Consultation Response from KC, Highways Development Management		
2020/90229 22, Lidgett Lane, Skelmanthorpe, Huddersfield, HD8 9AQ		
Outline application for demolition of detached dwelling and bakery and erection of 4 dwellings		
Date Responded: 27/02/2020	Responding Officer: Ryan Kinder	Responding Ref: K17-14/3

2020/90229 Lidgett Lane, Skelmanthorpe.

Title:
Proposed Site Plan

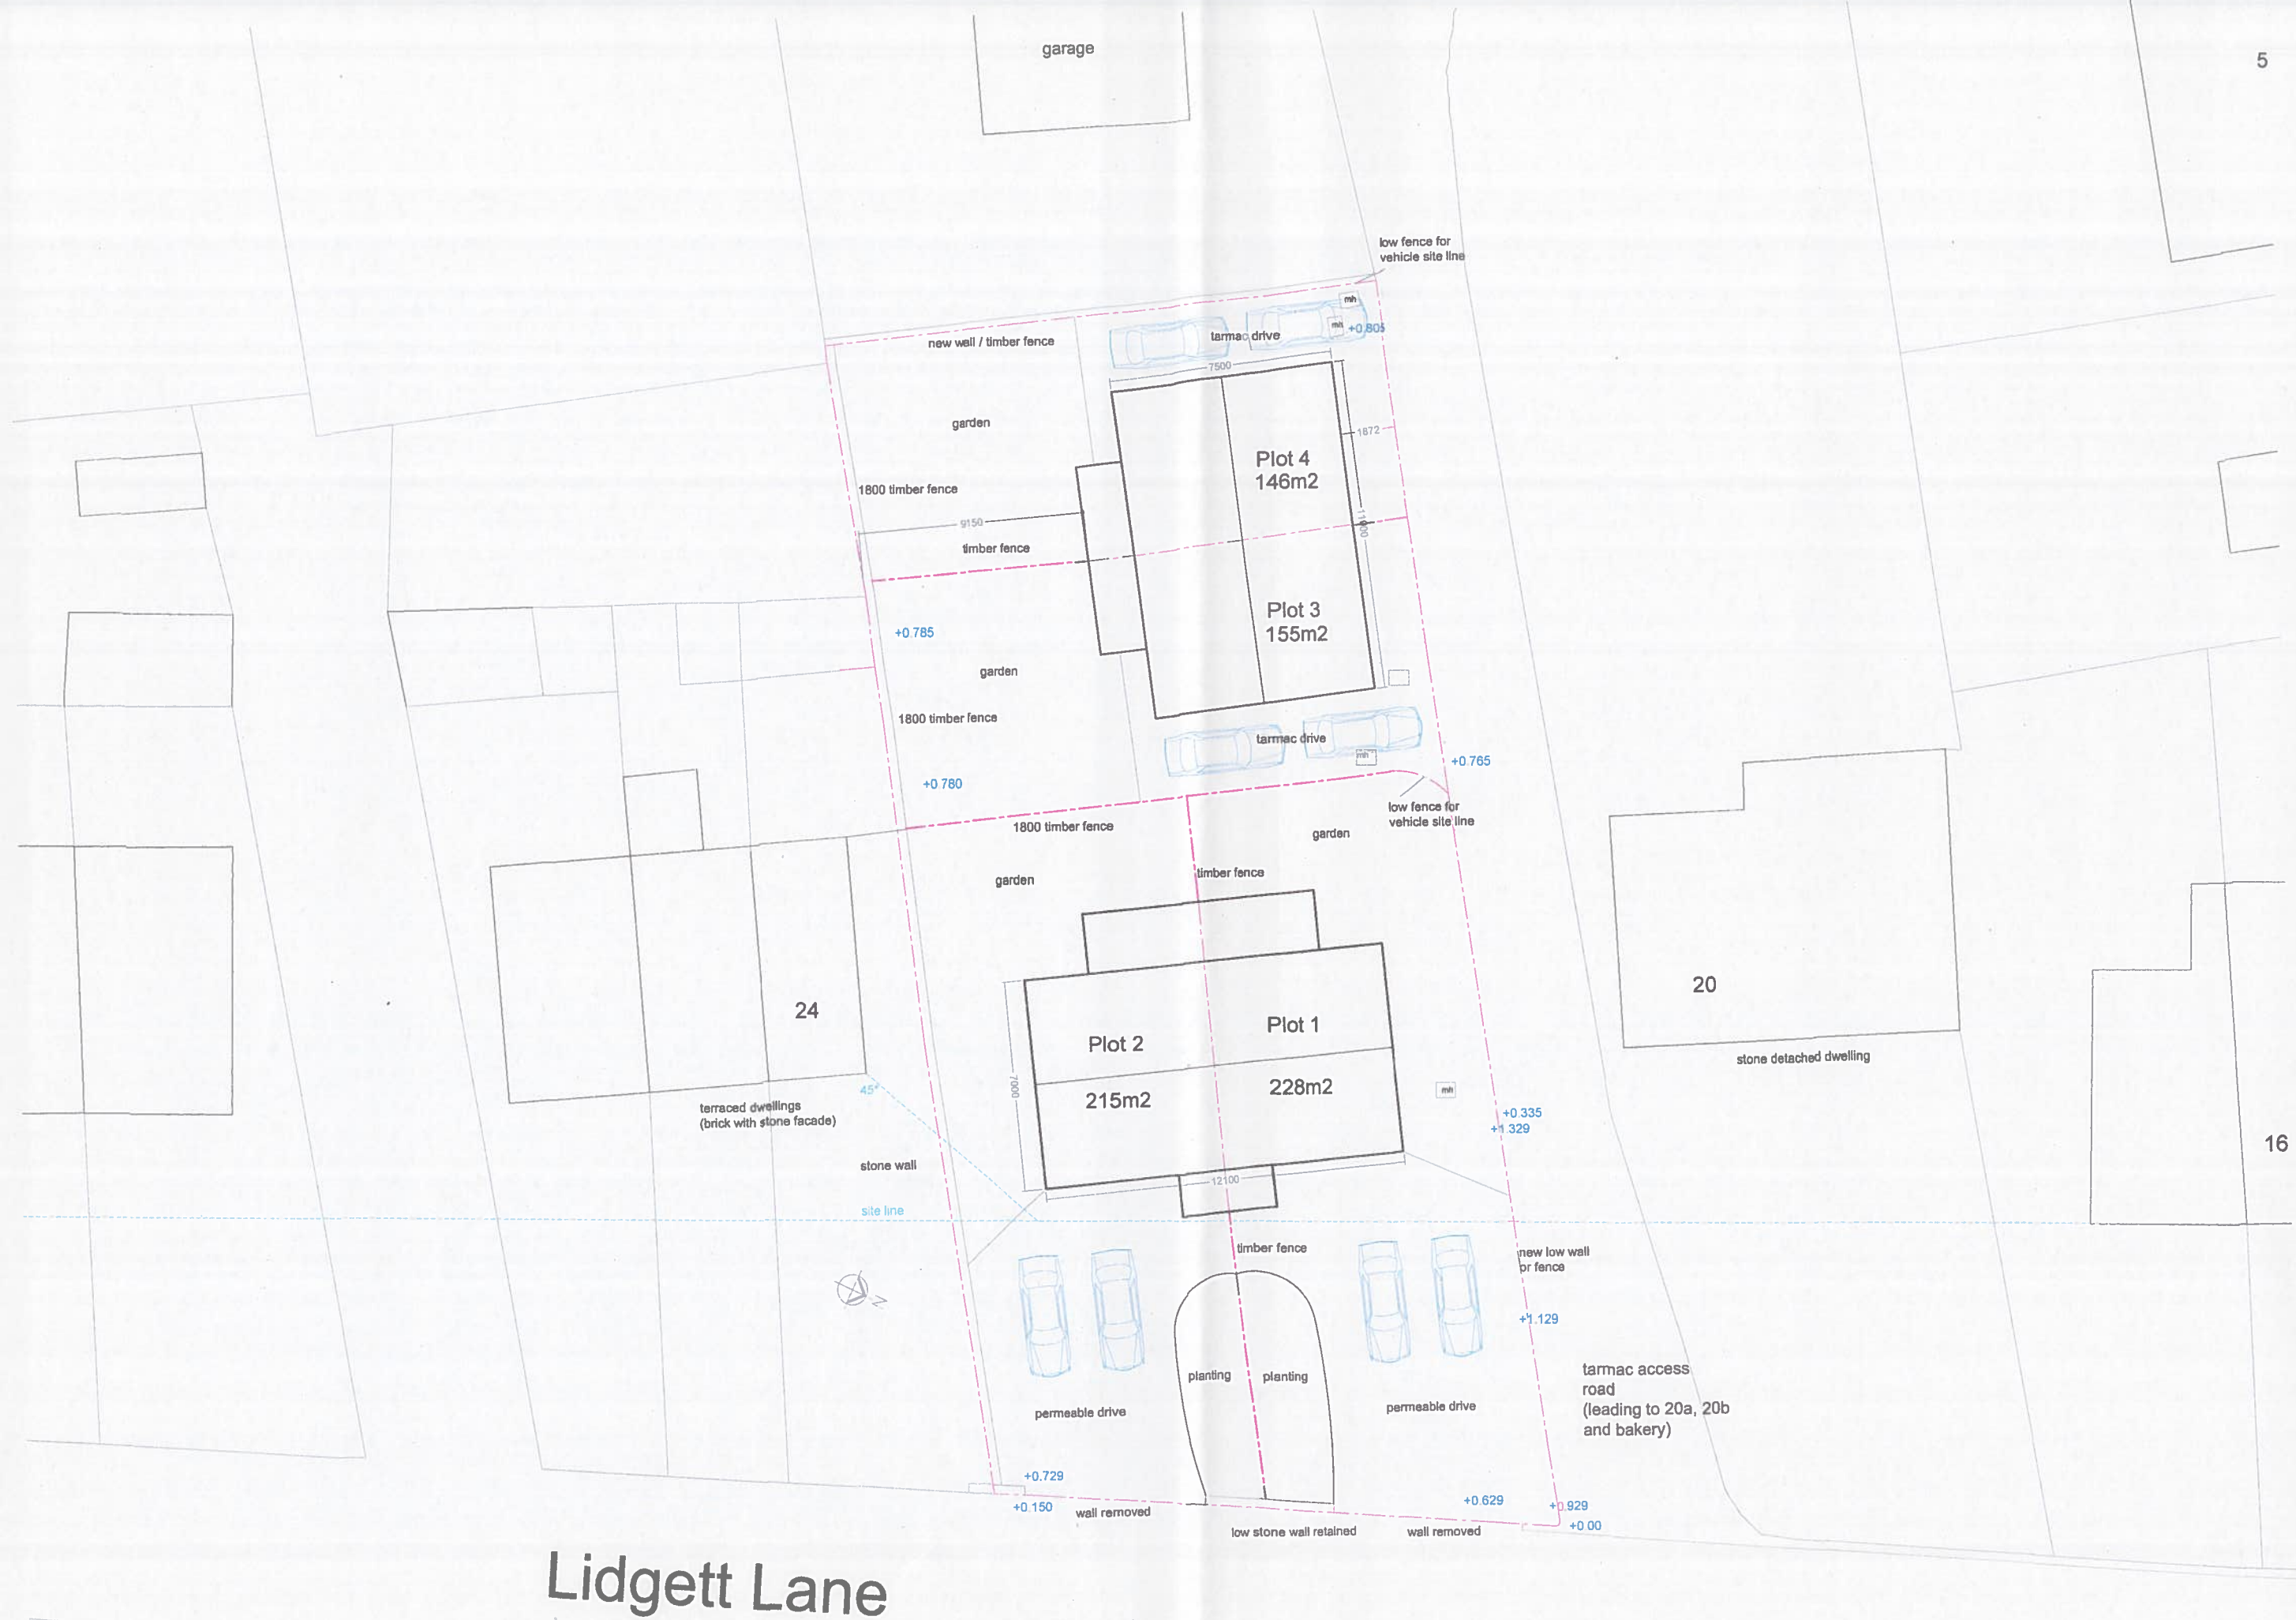
Access to the site is taken via Lidgett Lane onto a private driveway which currently serves the application site and two additional properties, the driveway is currently circa 3.3m-3.5m in width splaying wider at the site entrance with Lidgett Lane.

The current visibility onto Lidgett Lane is restricted to the northern side due to a neighbouring hedgerow, to the south is considered acceptable.

No information is provided regarding the storage and collection of refuse from the proposed development, a suitable accessible bin storage area ideally to the rear of the properties should be provided. A suitable bin collection point adjacent to but not on the existing highway should be provided and be sufficient to accommodate two wheelie bins per dwelling on collection days.

The proposed width of the private driveway is to remain as existing, in line with the Councils Supplementary Planning Document - Highway Design guide a road serving more than five dwellings should be but built to an adoptable standard having a minimum carriageway width of 5.5m plus footways drainage and street lighting. However in this instance may not be necessary due to the establishment of existing properties. The proposed width of the access should however be of a minimum width of 4.5m to allow two way vehicle movements, in addition sufficient sightlines should be provided at the junction with Lidgett Lane, for a 30 mph speed limit being 2.4m x 43m in line with Manual for Streets and demonstrated on a suitable plan accordingly.
